Your Ref :  
Our Ref : P/69/18/NMA

**Section 96A of the Town & Country Planning Act 1990 (as amended)**  
**Town and Country Planning (Development Management Procedure) (England) Order 2015 (as amended) - Article 10**  
**Non-material amendment following the grant of P/90/15/HH to change first floor window on rear elevation to french window & Juliet balcony.**  
**15 Lodsworth Road, Bognor Regis, ,**

PROPOSED 1ST FLOOR PLAN.

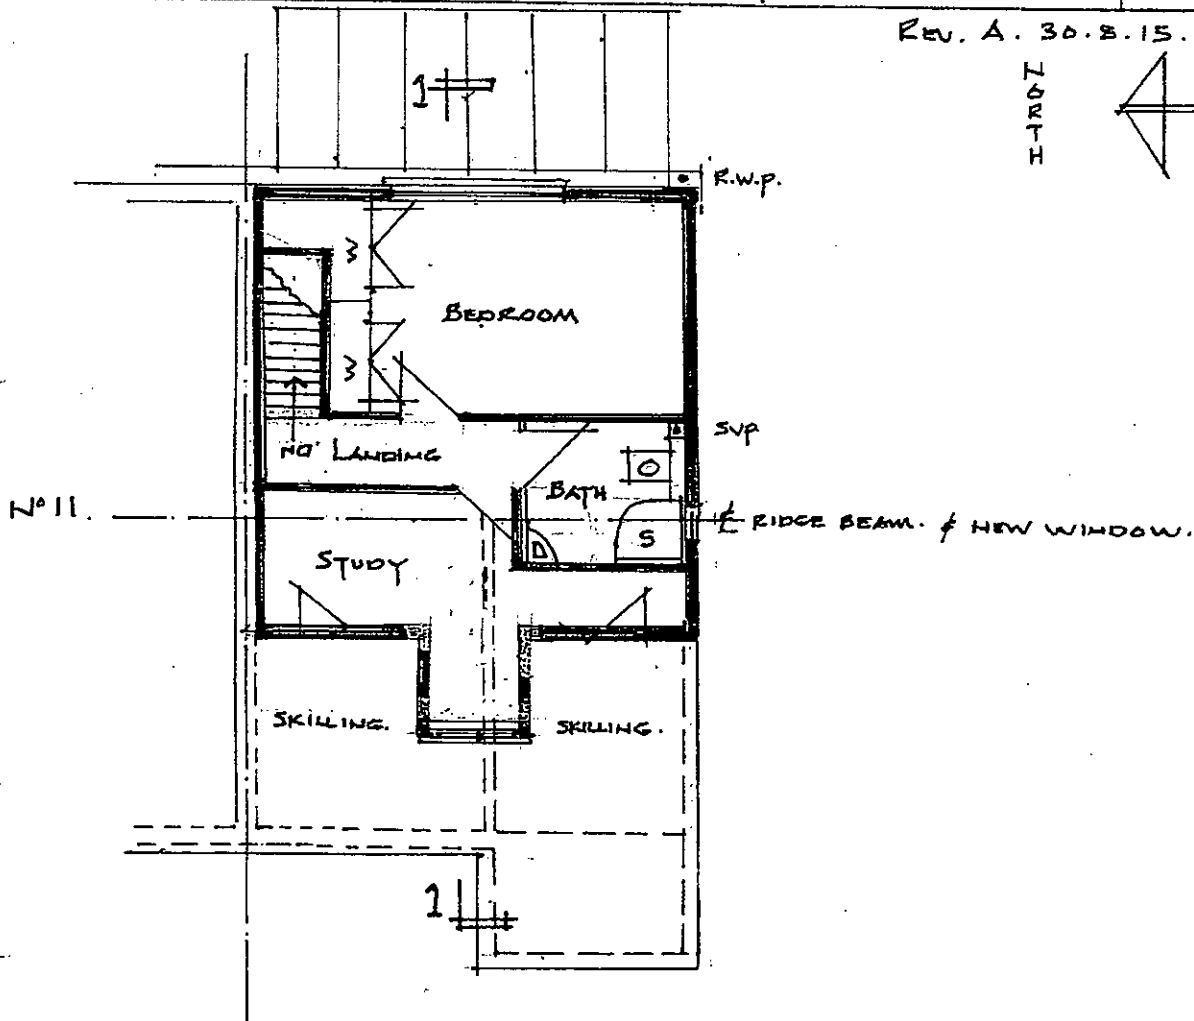
I note that we had an objection to the original application from a neighbouring property on the grounds of overlooking from the dormer window. I also note that the original officer report stated that: "The dormer would only have one window and this is not considered to introduce a level of communal overlooking of rear gardens that would be significant and result in a loss of privacy."

It is considered that the change from one typical sized window to French doors with a Juliette balcony would permit greater overlooking and as such the proposal cannot therefore be considered as a Minor Amendment under section 96A of the Town and Country Planning Act 1990. Therefore, you will need to apply for planning permission should you wish to pursue this.
